**RE: Defined Fitness at Unser Crossing
Grading and Drainage Plan
Engineer's Stamp Date: 10/23/18
Hydrology File: K10D045**

Based upon the information provided in your resubmittal received 11/08/2018, the Grading Plan **is not** approved for Building Permit. The following comments need to be addressed for approval of the above referenced project:

FIRST FLUSH BASINS

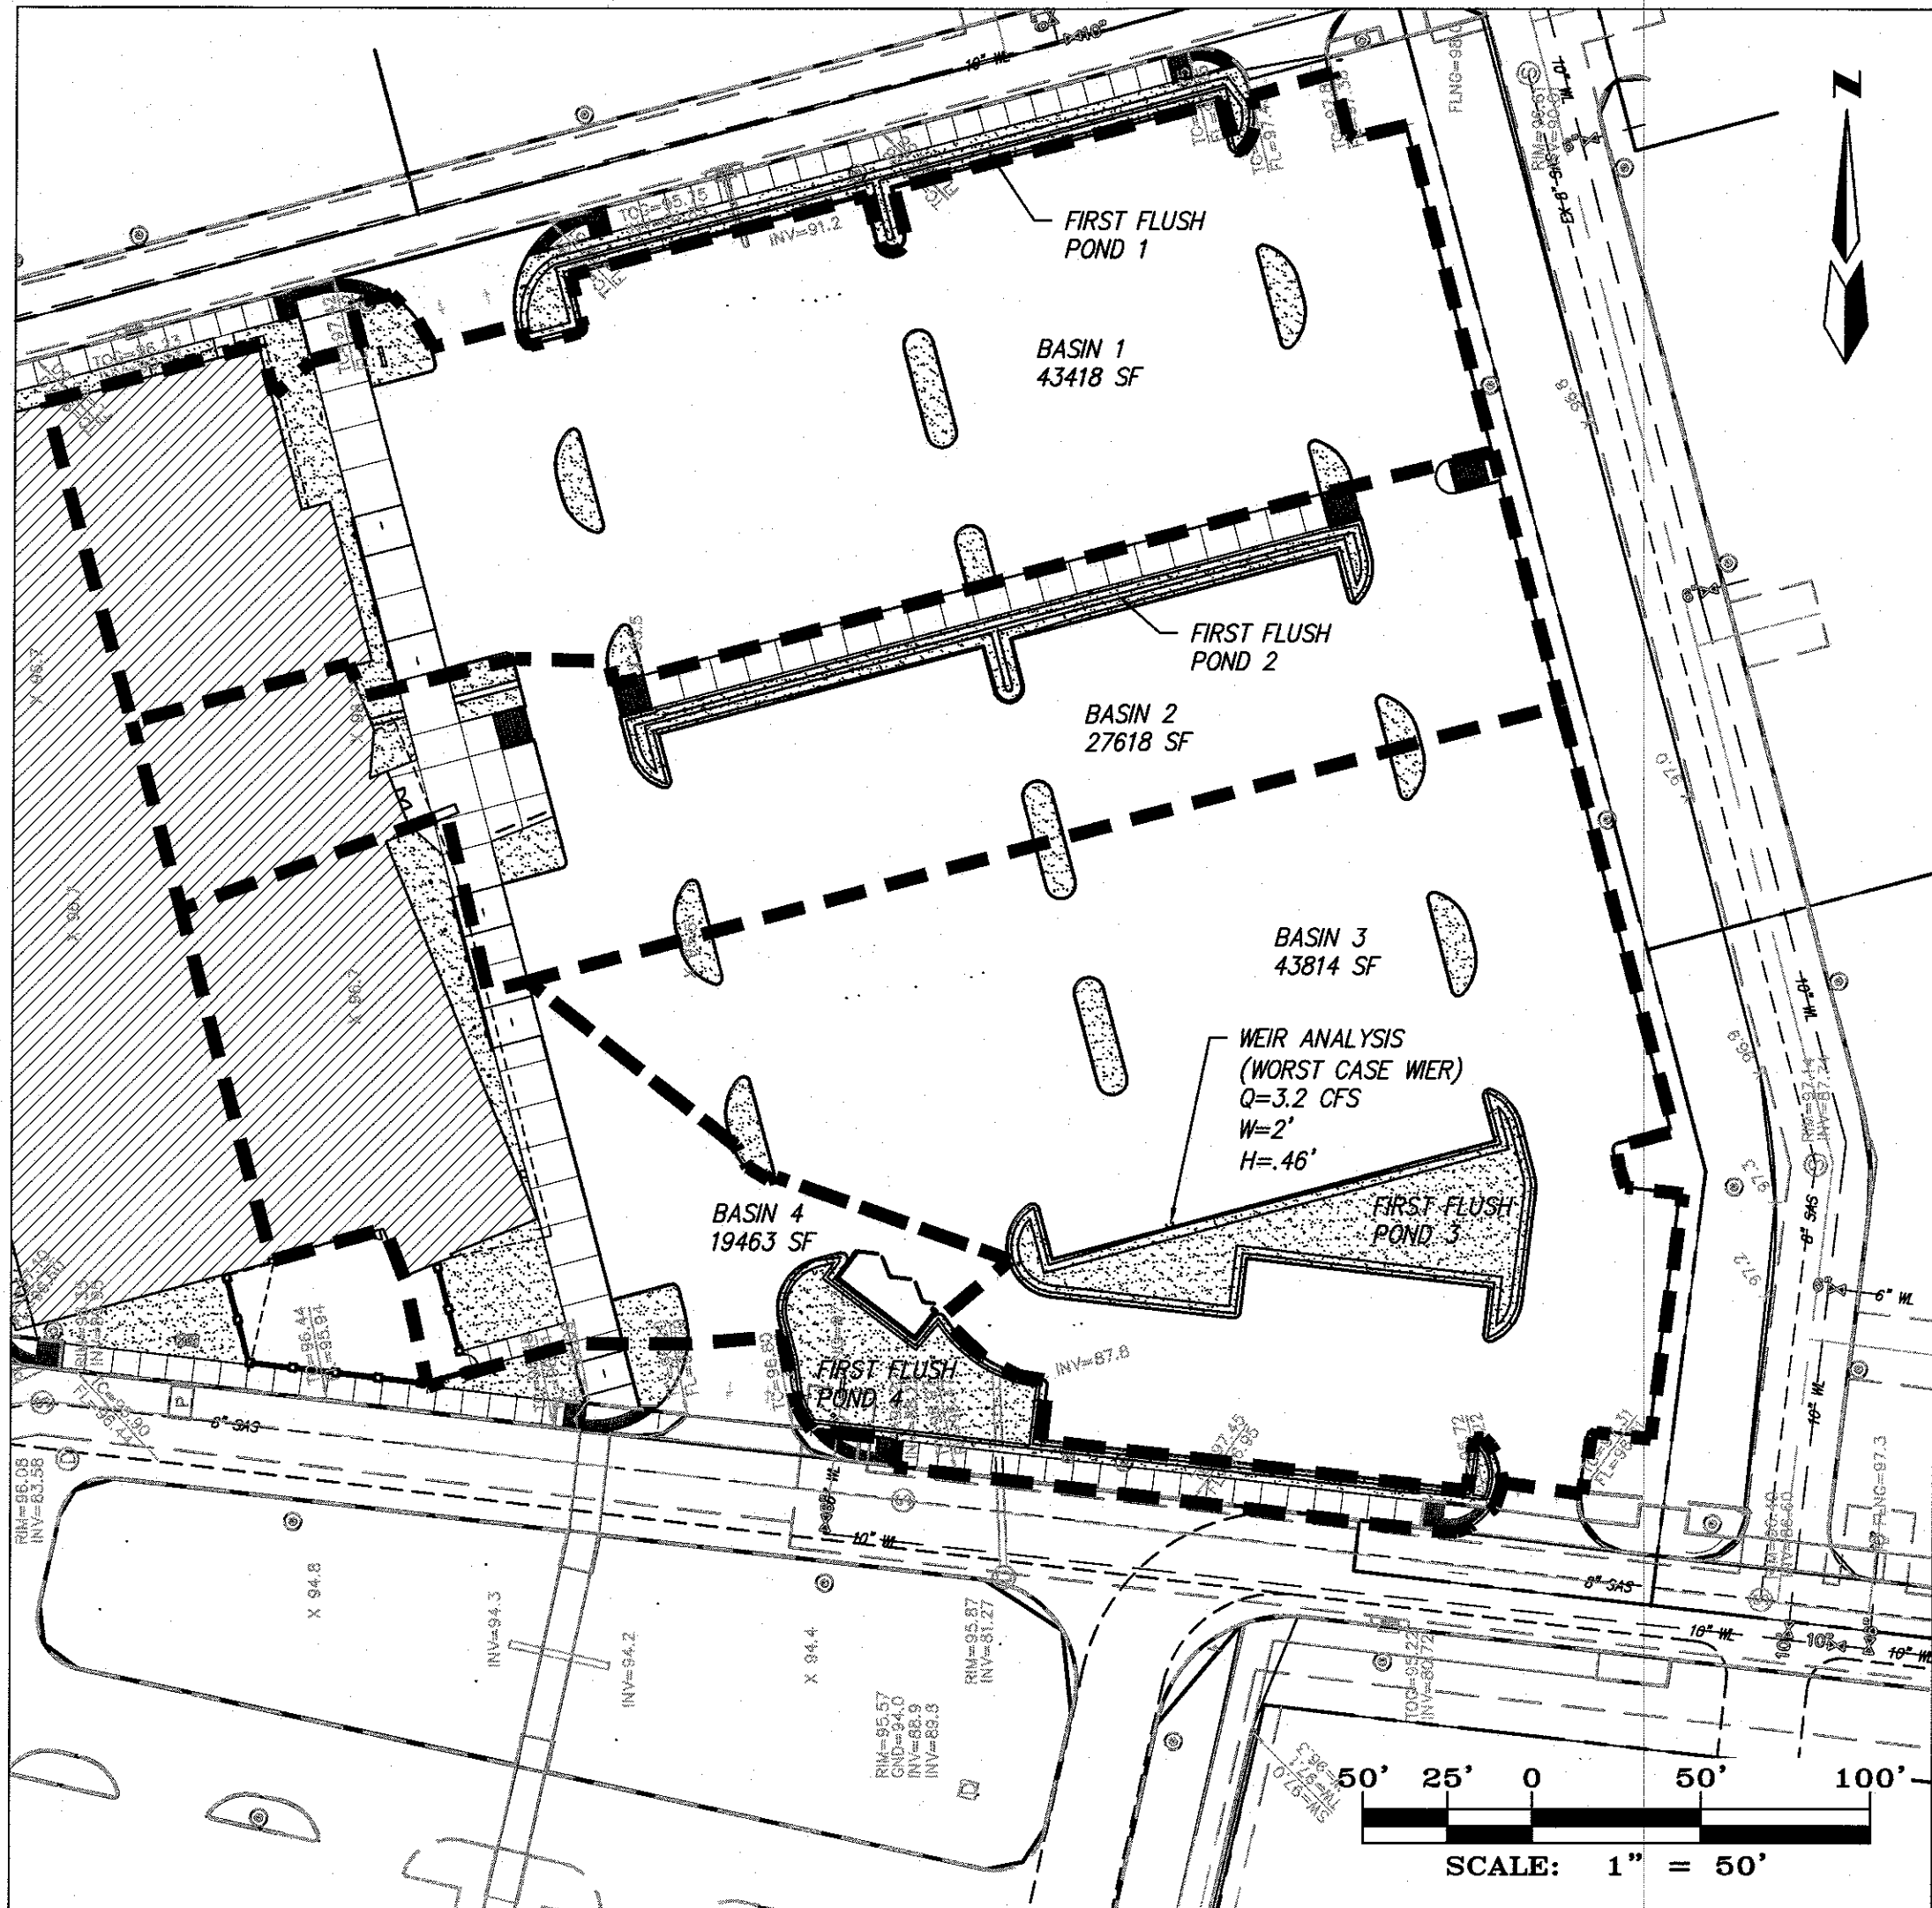
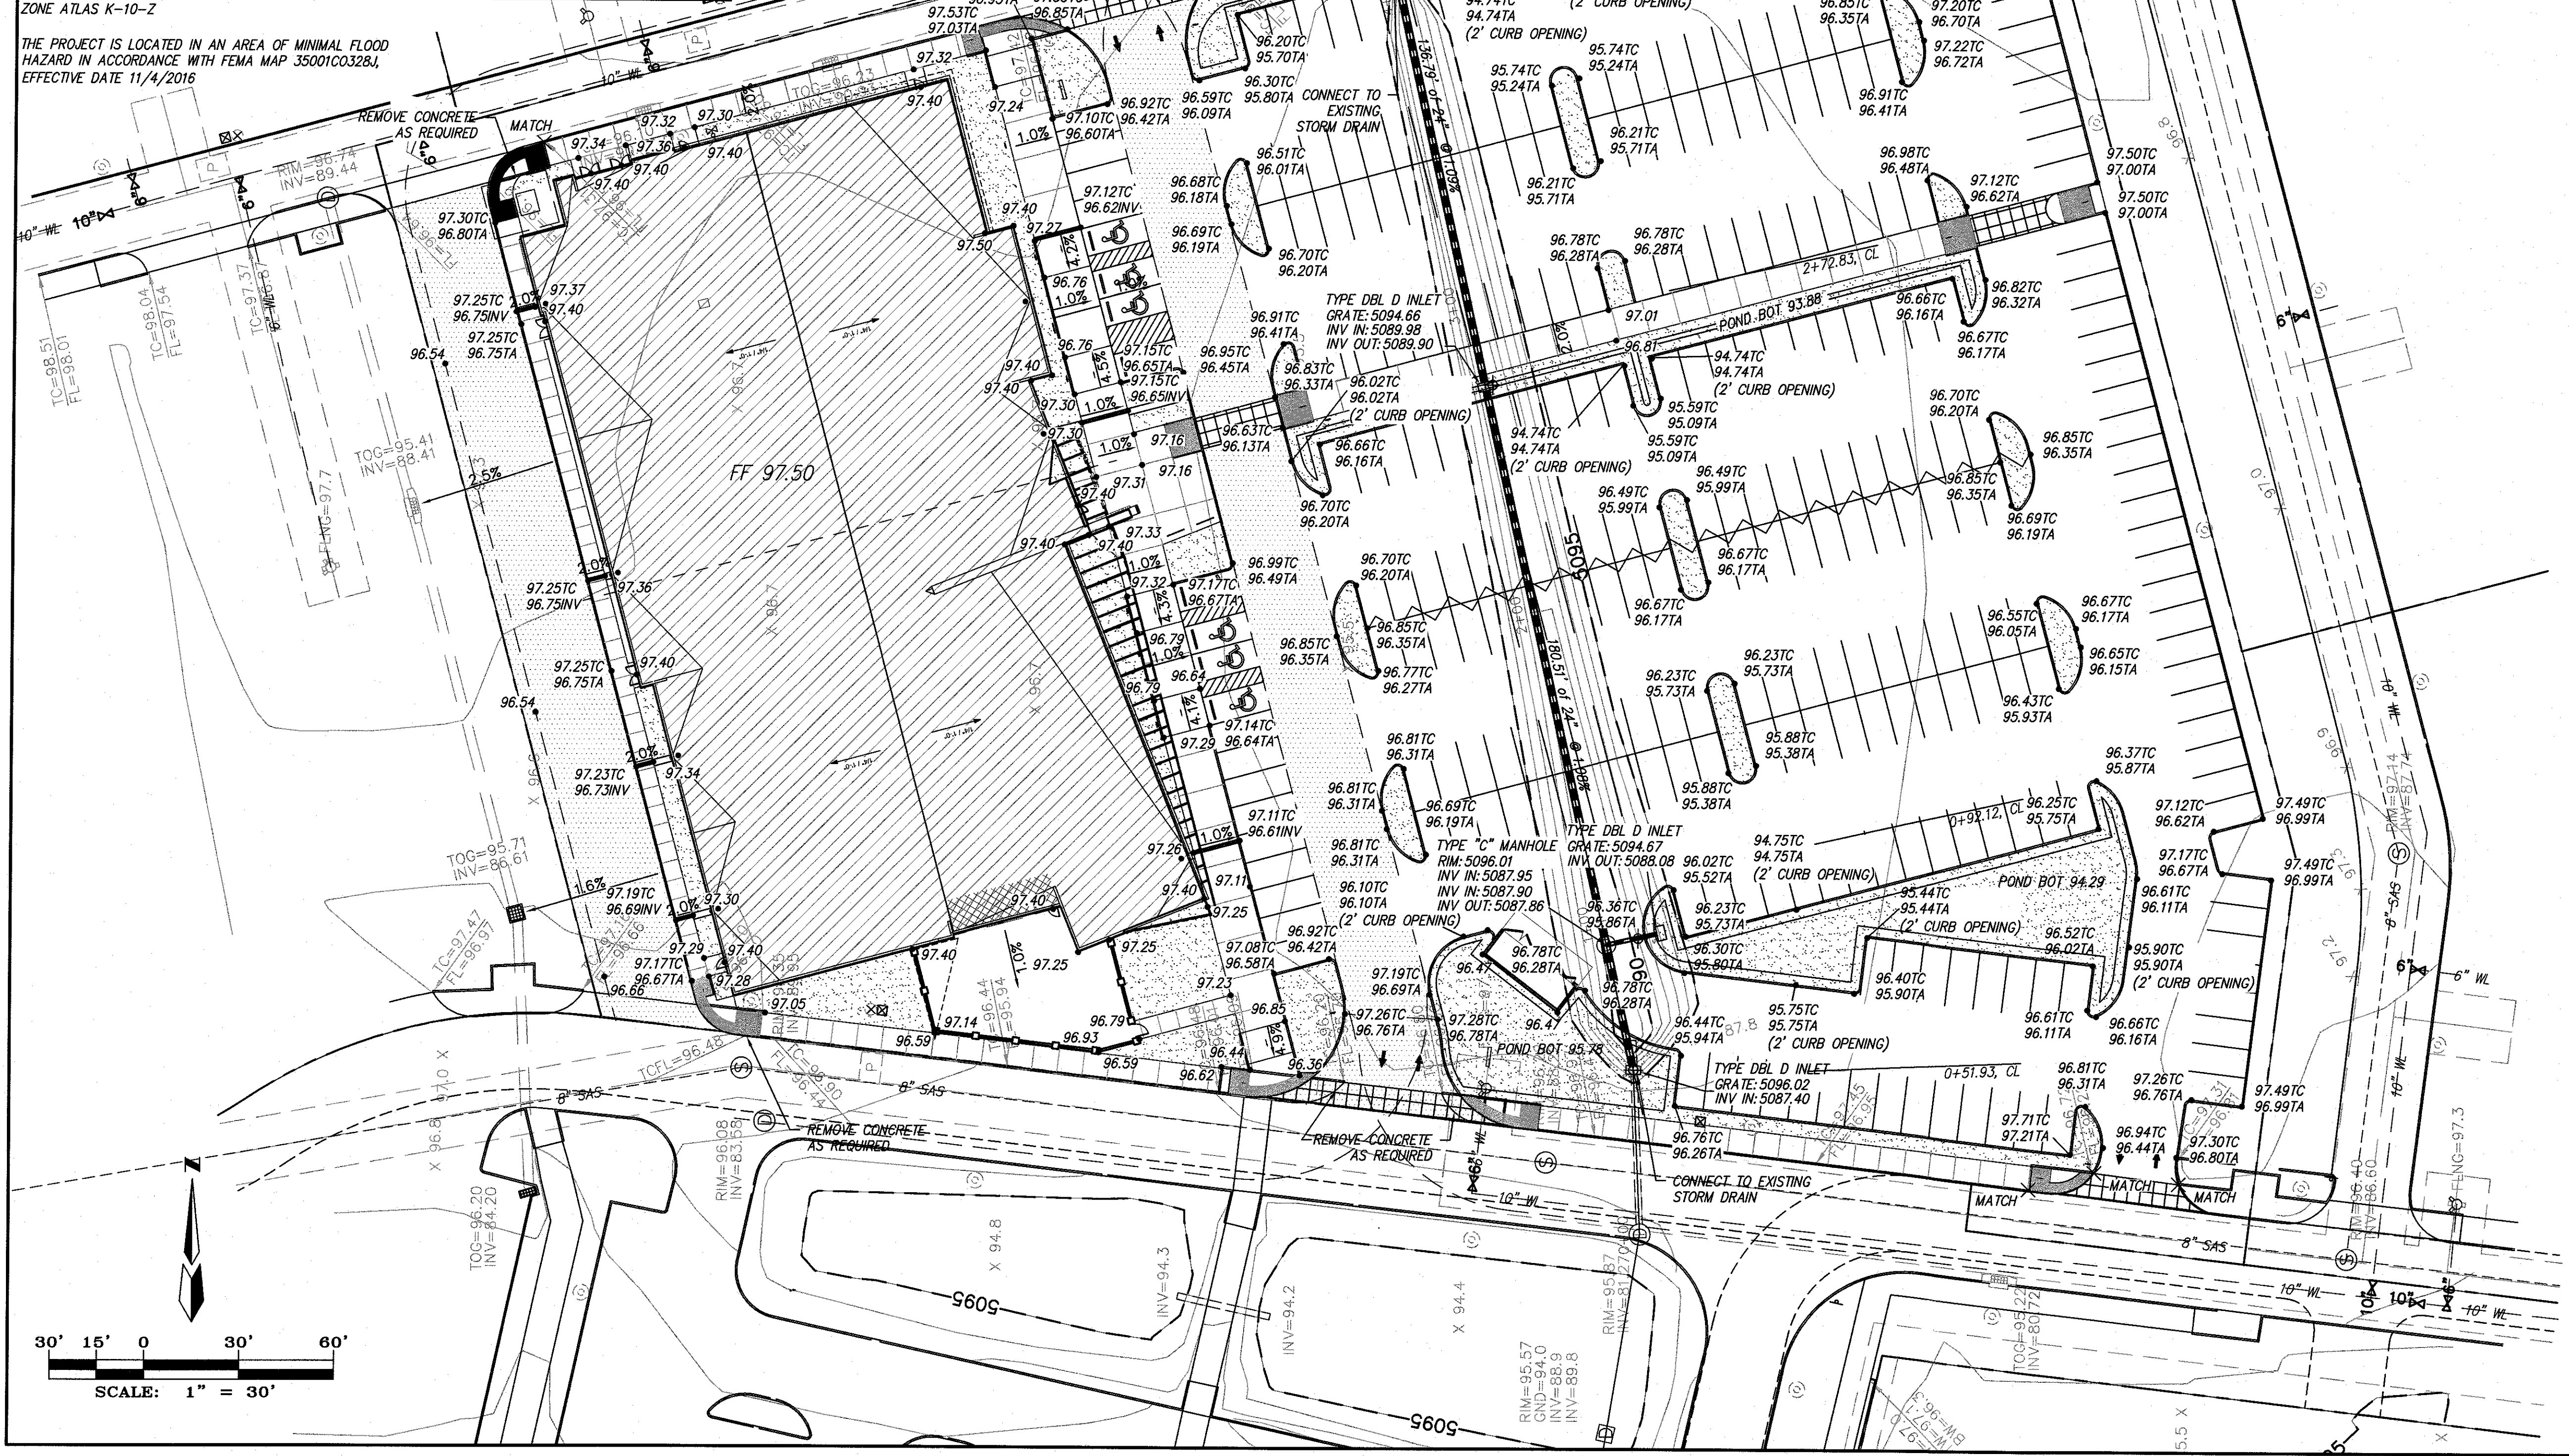
1. The above referenced project is within the 1959 City Boundary and therefore Payment in Lieu is not available. I have attached the approved amended Drainage Ordinance. Please follow General Provisions § 14-5-2-6-H. The important section is in Green and Blue. As far as the drainage area which discharges behind the building, this can be handled in a gravel trench at the edge of the pavement. Please revise the Grading and Drainage Plan which follows the amended Drainage Ordinance and send me revised pdfs of the plans and hard copy. Once I receive these, I will do my review. If you capture all the required Stormwater Quality Volume, then I will issue you an approval letter.
